**KIRKLEES METROPOLITAN COUNCIL
INVESTMENT & REGENERATION SERVICE**

DELEGATED DECISION TO DETERMINE PLANNING APPLICATIONS

Reference No:	2023/62/90359/W
Site Address:	51, Woodside Road, Beaumont Park, Huddersfield, HD4 5JF
Description:	Erection of two storey rear and side extensions including rear balcony and raised terrace, rear dormer extension and new roof with living accommodation in roof space
Recommending Officer:	Laura Yeadon

DECISION – REFUSED

Drawing Number:
22-082-05

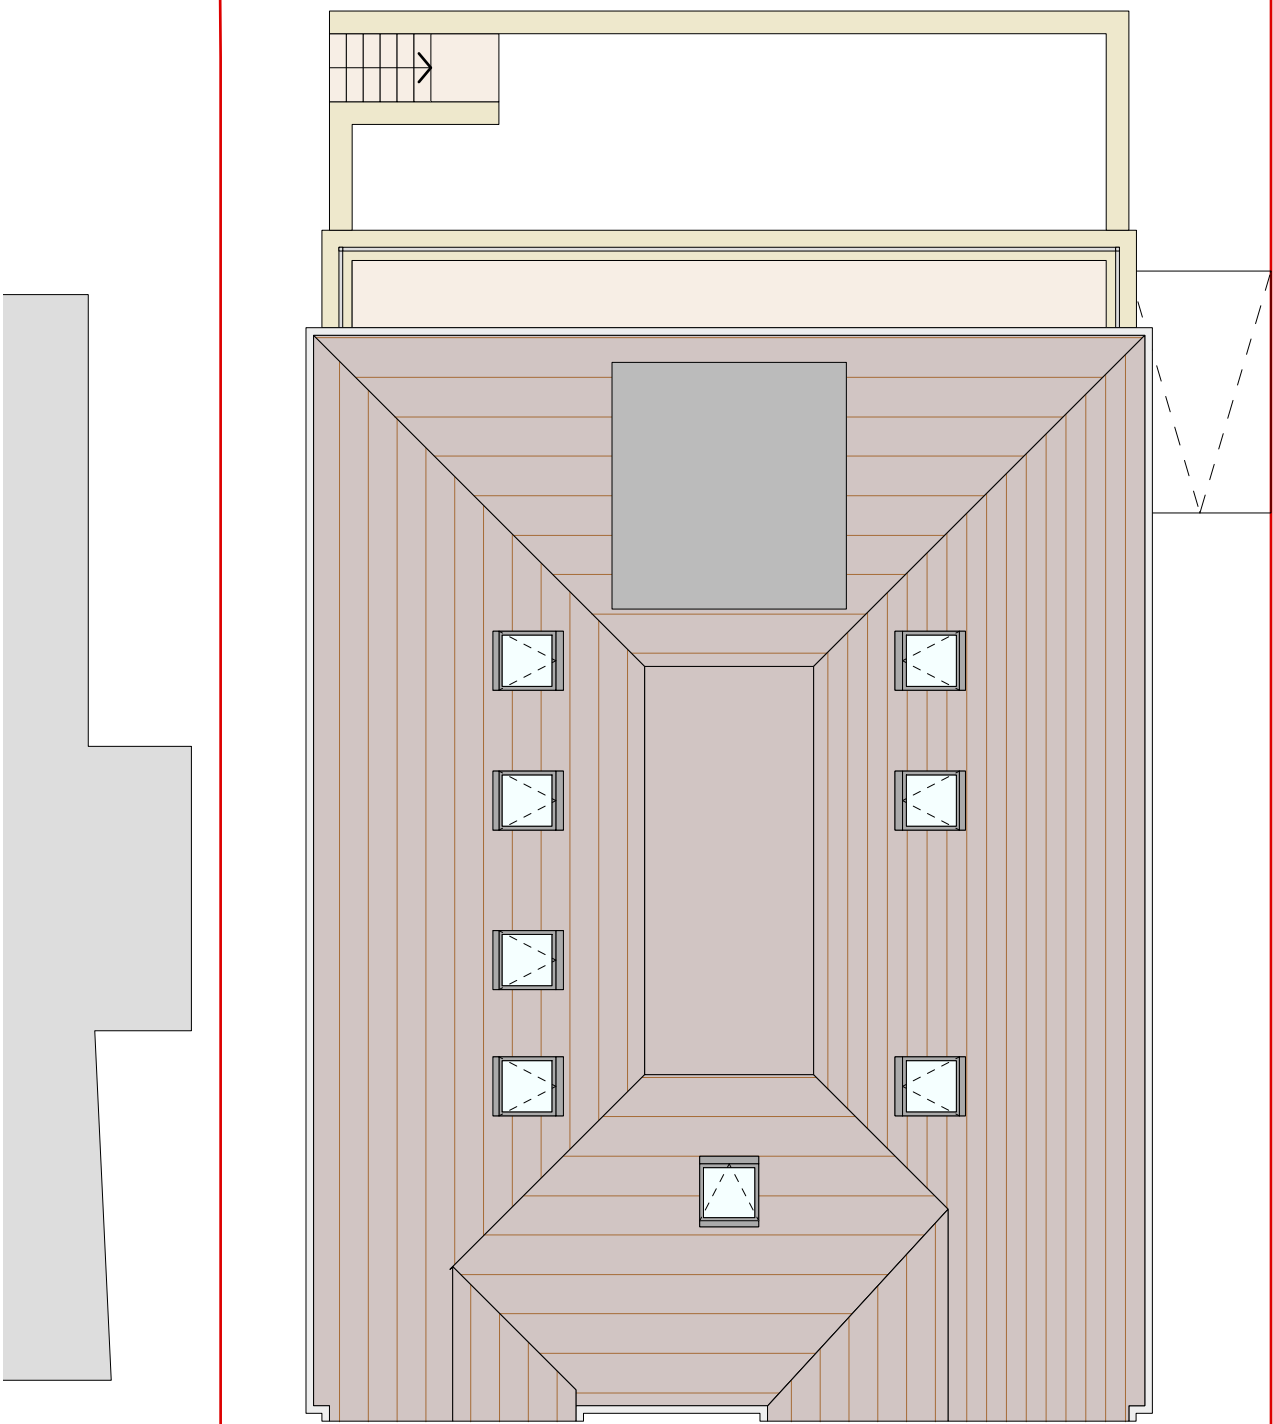
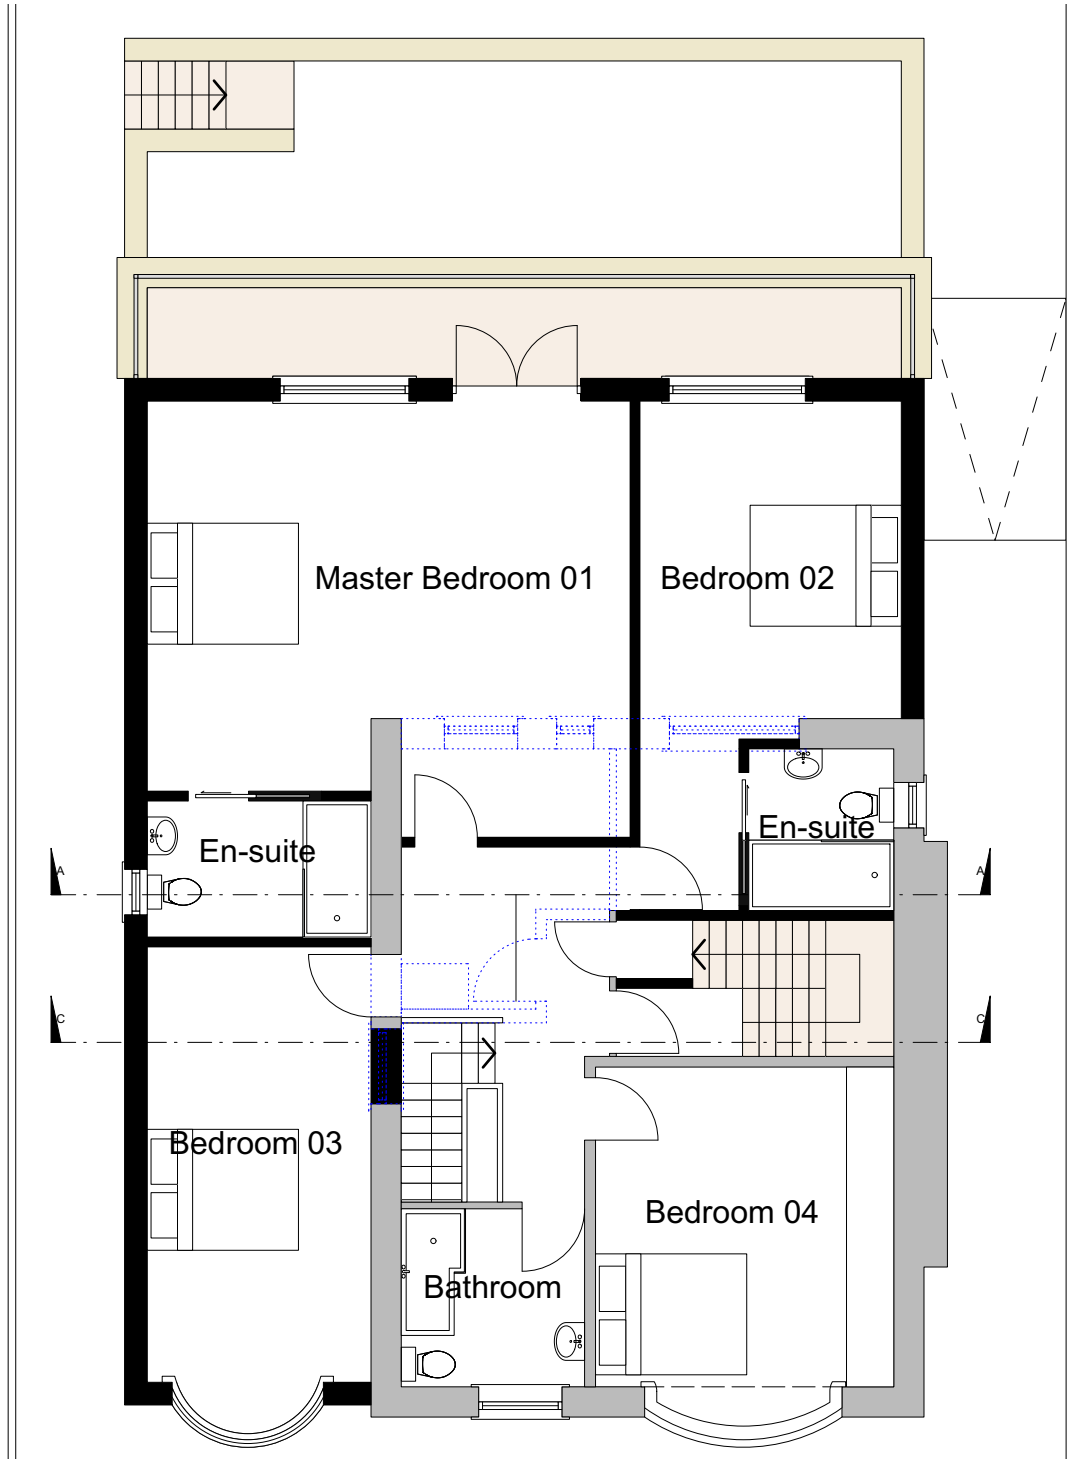
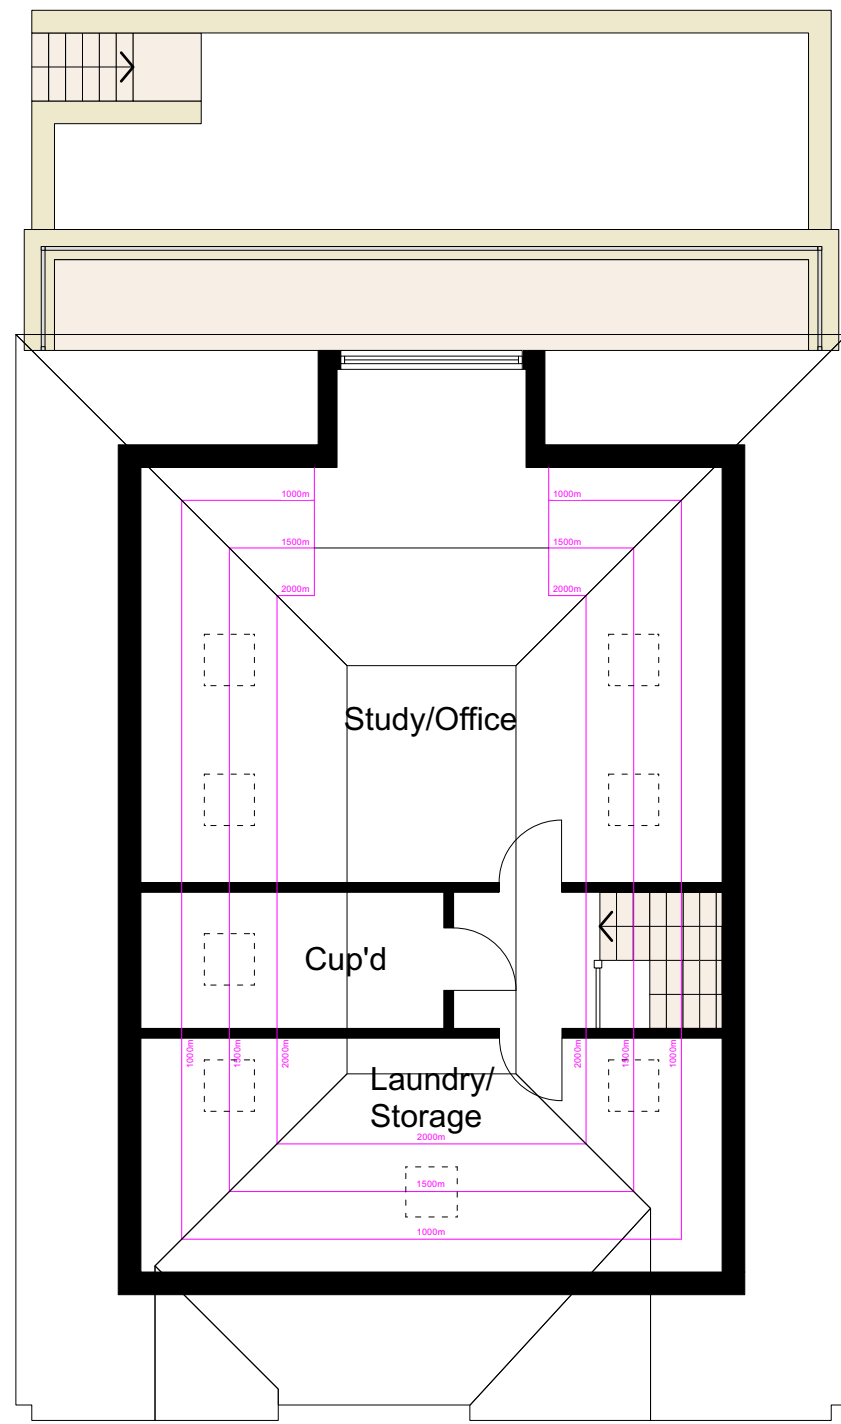
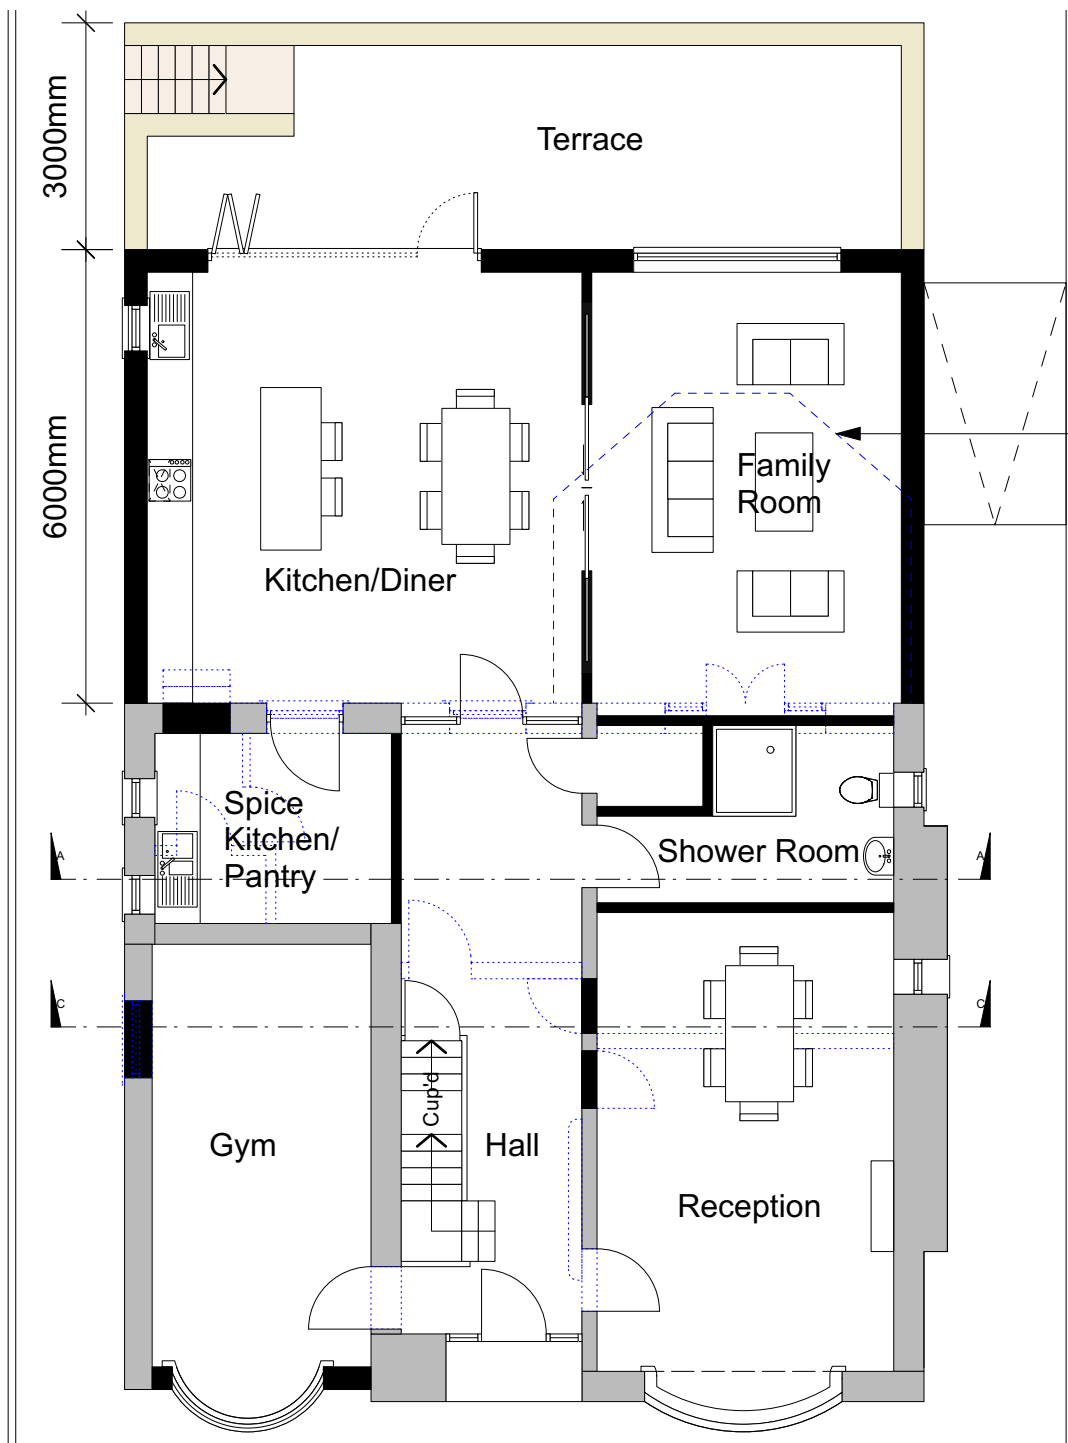
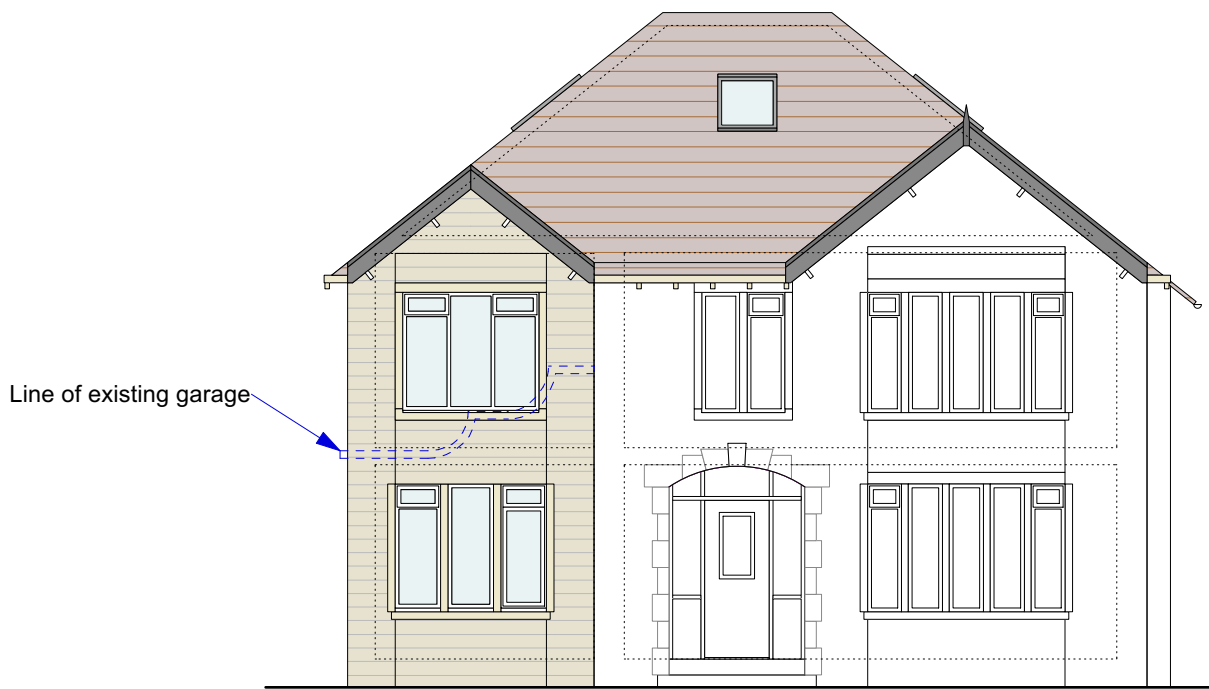
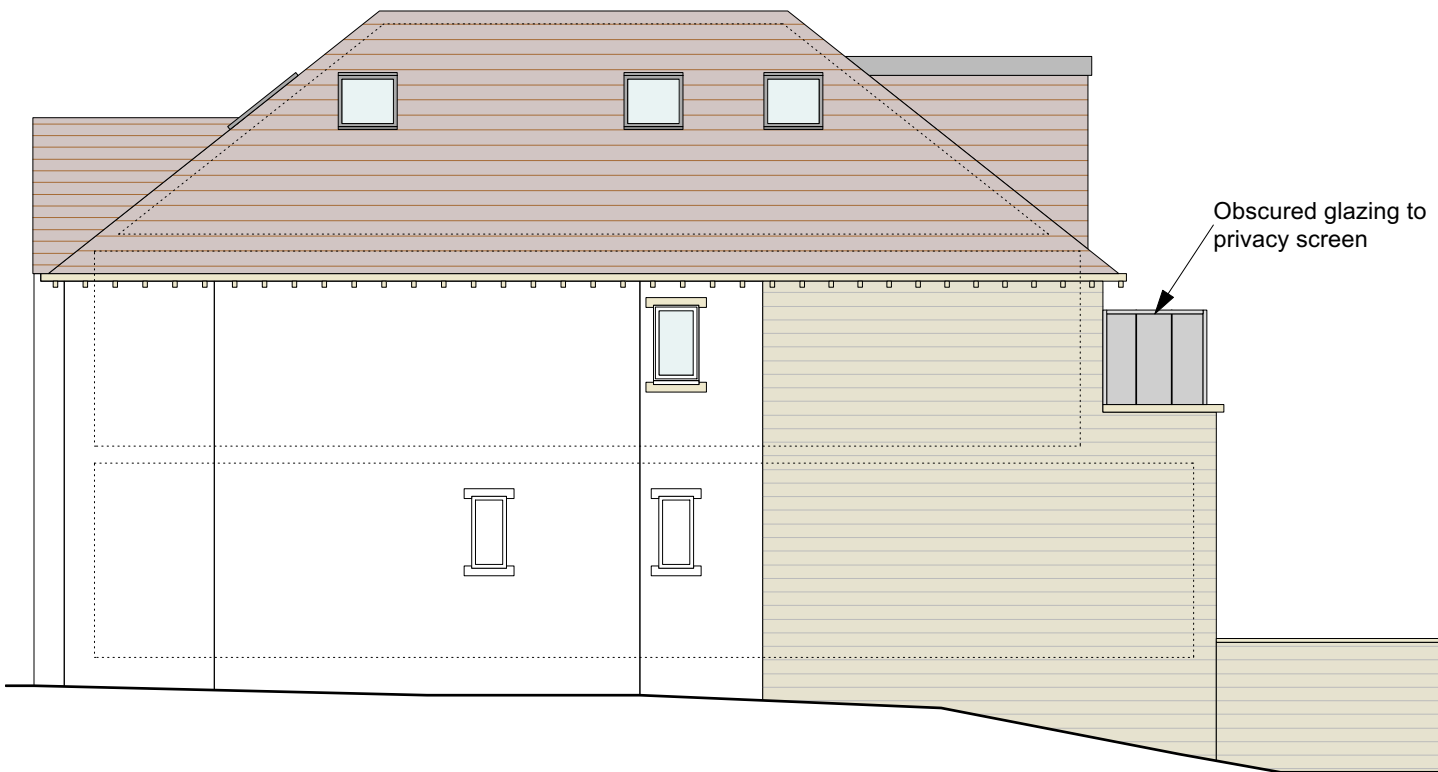
building line. It goes on to explain that two storey extensions should be set down from the ridge and generally smaller in footprint. It is noted that the proposed first floor side extension would be set back slightly from the existing front elevation of the property however due to the proposed increase in height of the property and the proposed projection which, when including the proposed terrace, would approximately double the size of the property. As such, due to the overall projections both in terms of footprint and increased height, the overall size, scale and massing of the proposed works would not be considered to be subservient to the original property and therefore contrary to Key Design Principle 2 of the SPD.

In terms of the rear extension, it is not considered that the proposal would comply with sub-paragraph 5.8 of the SPD. The proposed extensions and terrace would not be proportionate to the size of the original property and whilst there would be sufficient garden space remaining, the proposed works far exceeds the parameters of the SPD which states that extensions should not exceed more than 4 metres on detached properties. The extension itself would project 6 metres at two storey height and 9 metres including the terrace which would not comply with the SPD and would be visually disproportionate, visually intrusive and out of character with the host and surrounding development. Cumulatively the extensions, including the proposed terrace, balcony and dormer extension alongside the increased height of the dwelling would not present and subordinate addition, presenting an undue level of bulk and massing to the side and rear of the property. In addition, in terms of the visual impact in the neighbouring dwellings, the extensions would be unsympathetic, dominant and oppressive.

In terms of the proposed balcony and terrace, whilst terraced areas are common within the street scene due to the difference in levels, it is considered reasonable that some form of terrace could be supported. However, given that it would attach to the 6m projecting extension, it is considered that this addition would be visually intrusive when viewed cumulatively. The proposed balcony would introduce an uncommon feature within the street scene which would be visually imposing due to the overall scale and massing of the works.

With regards to the proposed dormer extension, this would appear cramped within the rear elevation roof slope. In terms of the SPD, whilst the dormer would be constructed from hung tiles, it would dominate the rear elevation roof slope due to the roof design, as such, would be contrary to sub-paragraph 5.27 of the SPD.

In terms of the impact on neighbouring dwellings, the works would be located to the south-west of No. 49 and to the north-east of No. 53. With regards to the impact on these properties, the application site is on a higher ground level to the No. 49 neighbour and therefore to bring the overall scale and massing closer to this property is considered to be detrimental in terms of being an oppressive feature which would tower over the single storey rear extension to this neighbour and would it is noted it would reduce the natural light to the side elevation windows and roof areas of this property where openings are located.

Given the projection / massing of the proposal located close to the shared boundary it is considered that the works would result in an oppressive development that would be overbearing and dominant when viewed from neighbouring properties including with their amenity spaces.

Whilst the openings are limited within the side elevation facing this property overlooking would occur from the proposed terrace and balcony area. In terms of the impact on No. 53, again the development would be oppressive to this property with a stark blank elevation facing this neighbour.

1. The proposed extension by reason of its design, scale and massing would not be of a subservient design and would appear as an incongruous and discordant addition to the host dwelling, which would, in turn, harm the character and appearance of the dwelling and the wider street scene. The proposal is therefore be contrary to Policy LP24(a) and (c) of the Kirklees Local Plan, Key Design Principles 1 and 2 of the Kirklees House Extensions and Alterations Supplementary Planning Document and Policy set out in Chapter 12 of the National Planning Policy Framework.

2. The proposed extension, by virtue of its scale, design and siting in relation to shared boundaries, would have a detrimental impact to neighbouring occupiers forming an overly overbearing and oppressive impact and would result in overlooking to the occupiers of No.'s 49 and 53 Woodside Road. Therefore, the proposal would fail to retain a high standard of amenity for the occupiers of these neighbouring dwellings contrary to Policy LP24(b) of the Kirklees Local Plan, Design Principles 3, 4, 5 and 6 of the Kirklees House Extensions and Alterations Supplementary Planning Document and policy within Chapter 12 of the National Planning Policy Framework.
